SITE PLAN APPLICATION
218-220 WASHINGTON AVENUE
WRITTEN SUBMISSION S – 4 RESPONSES TO REVIEW COMMENTS

THESE RESPONSES TO COMMENTS ARE BASED UON THE STAFF REPORT AUTHORED BY JEAN FRASER AND DATED JULY 7, 2017.

BRICK DRIVEWAY APRON WITH BITUMINOUS BASE
NOT TO SCALE

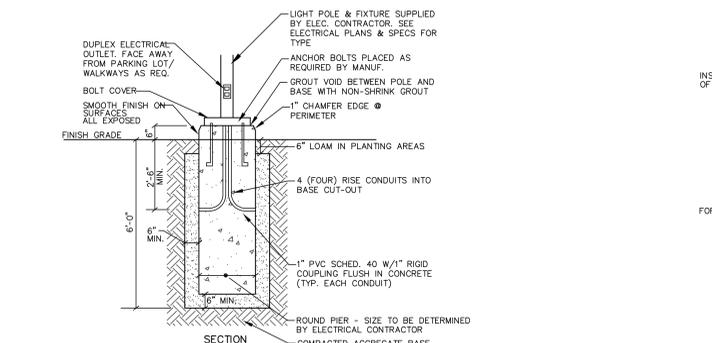
- A WAIVER HAS BEEN REQUESTED FOR DRIVEWAY SEPARATION – SEE REVISED WRITTEN SUBMISSION F.
- A WAIVER HAS BEEN REQUESTED FOR CORNER CLEARANCE – SEE REVISED WRITTEN SUBMISSION F.
- THE CONSTRUCTION MANAGEMENT PLAN HAS BEEN REVISED – SEE REVISED WRITTEN SUBMISSION I.
- THE TANDEM PARKING SPACES IN THE GARAGE ARE ACTUALLY NOT TANDEM SPACES – THE AREA IN FRONTN OF THE USEABLE SPACES WILL BE USED FOR STORAGE.
- WRITTEN SUBMISSION S- 7 DEMONSTRATES THA VEHICLES WILL NOT HAVE TO BACK OUT OF THE SITE.
- AS REQUESTED A SHORT NARROW LEFT TURN LANE IS NOW PROPOSED AT THE EASTERN PROMENADE INTERSECTION.
- THE DRIVEWAY APRON HAS A MAXIMUM CROSS SLOPE OF 2% AND HAS BEEN CHANGED TO BRICK PAVERS.
